Application for Removal or Variation of a Condition following Grant of Planning Permission or Listed Building Consent

Refurbishment and conversion of outbuildings to detached dwelling.

2024/0195

Condition 2: The development hereby approved shall be carried out strictly in accordance with the amended plans (Nos. FP-20DR 01 May 2024; FP-20DR 02 May 2024; FP-20DR 03 May 2024; FP-20DR 04 May 2024; FP-20DR 05 May 2024; FP-20DR 06 May 2024; FP-20DR 07 May 2024; FP-20DR 08 May 2024; FP-20DR 09 May 2024;) and specifications as approved unless required by any other conditions in this permission.

Site Address: 20 Darton Road, Cawthorne, Barnsley, S75 4HR			
Project: Refurbishment and Conversion of Outbuildings			
Drawing title: Proposed Elevations			
Status: Planning	Date: May 2024		
Project no: FP-20DR	Drawing no: 05	Revision: A	Scale: 1:100@A3

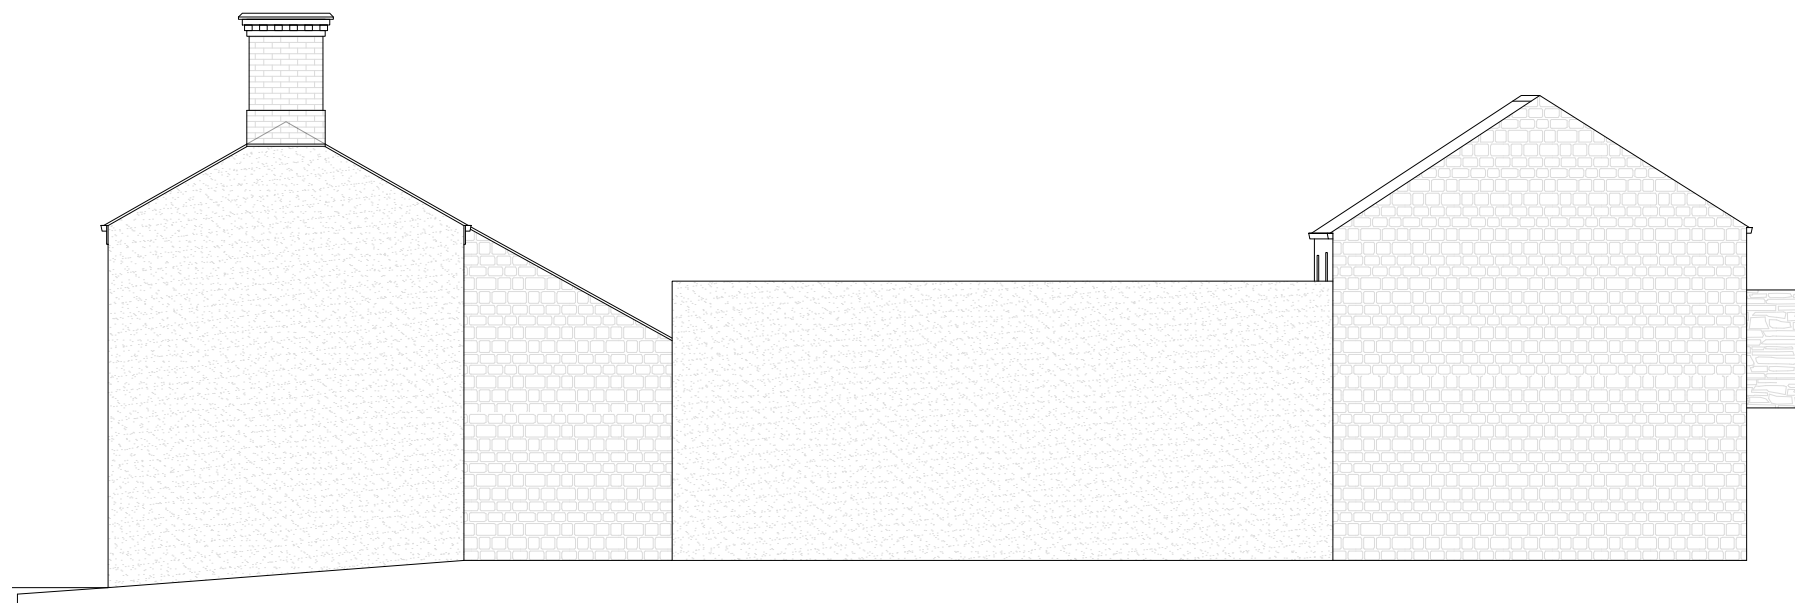
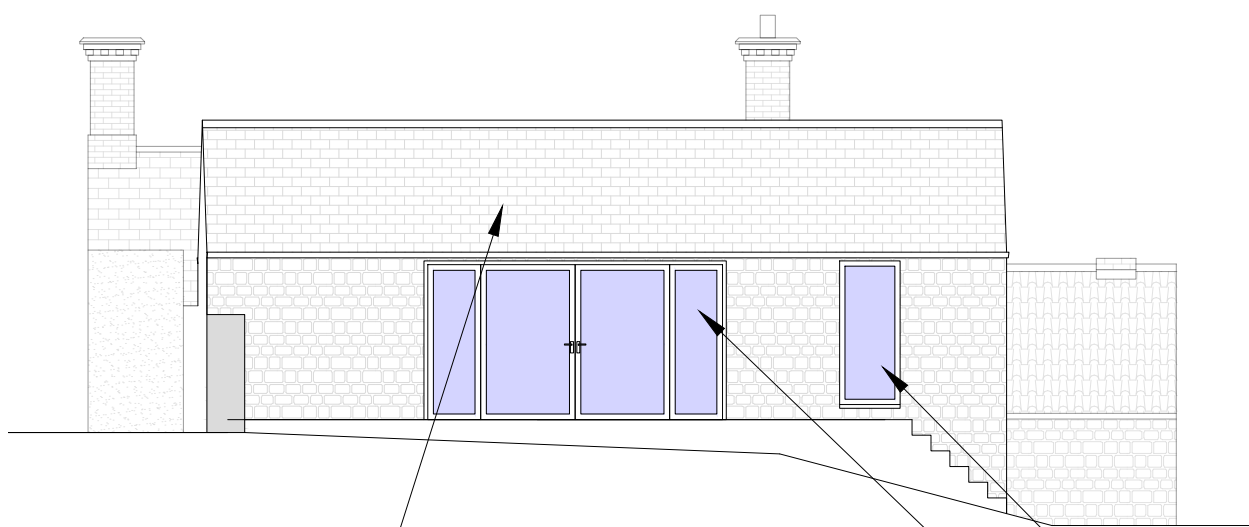
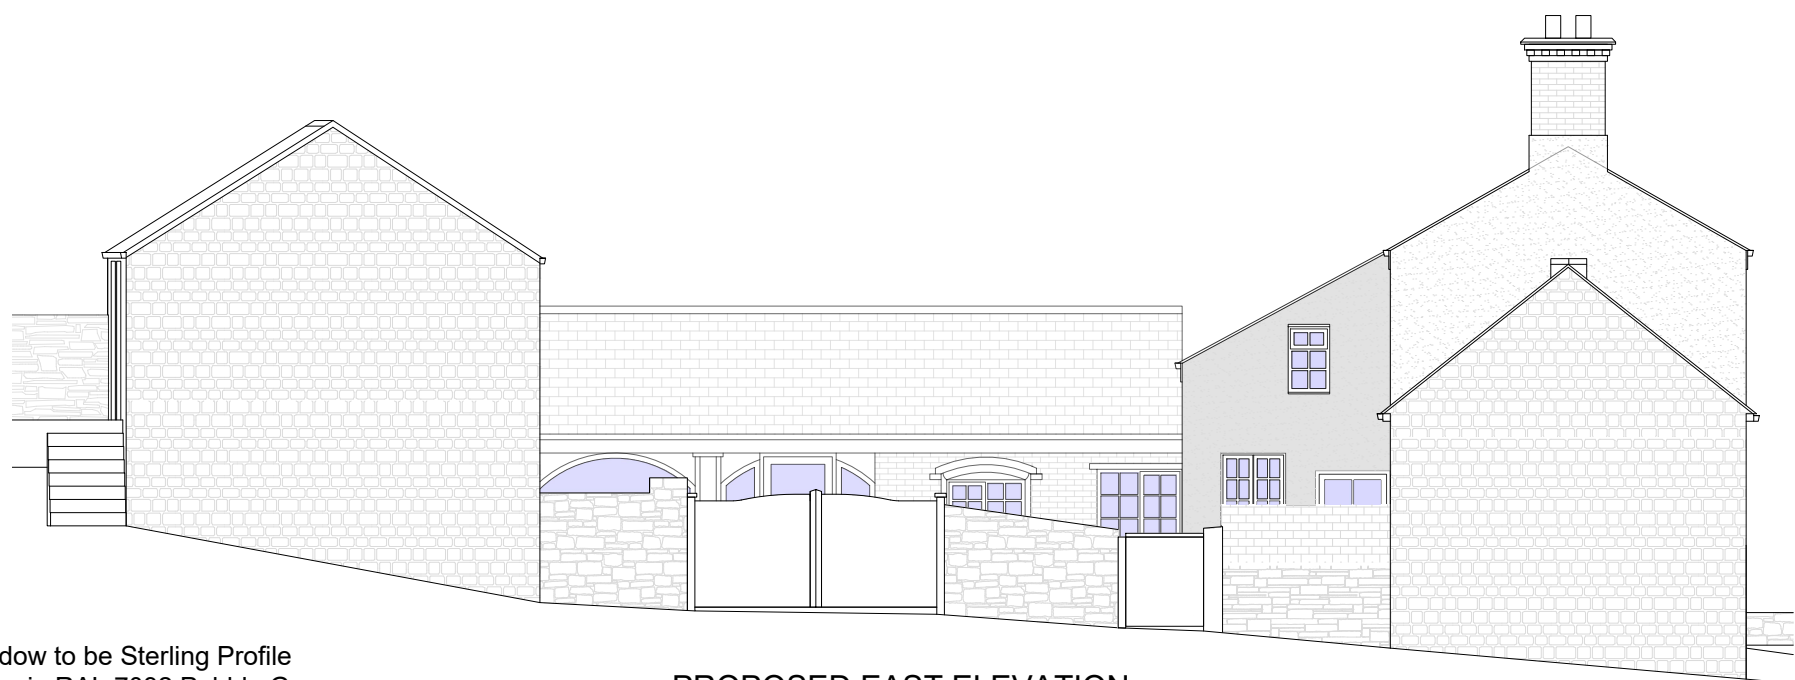
1. Variation to Condition 2 – Approved Drawings - Replacement of the approved plans to reflect the following design changes:
 - Revised layout of windows and bifold doors on the rear barn conversion to enhance usability, light, and access to external amenity space.
 - Demolition of the barn gable end and reconstruction to modestly reduce the width of the building to improve vehicular access and parking to the rear.
2. Variation to Condition 3 – Windows and Doors Specification - Amendment of the approved materials from "Cotswold SMART aluminium framed in off white / cream (CDW003)" to:
 - Windows: Sterling Profile aluminium in RAL 7032 Pebble Grey (Barn rear elevation only)
 - Doors: Sherline Profile aluminium in Traditional Panel Effect, also in RAL 7032 Pebble Grey (Barn rear elevation only)
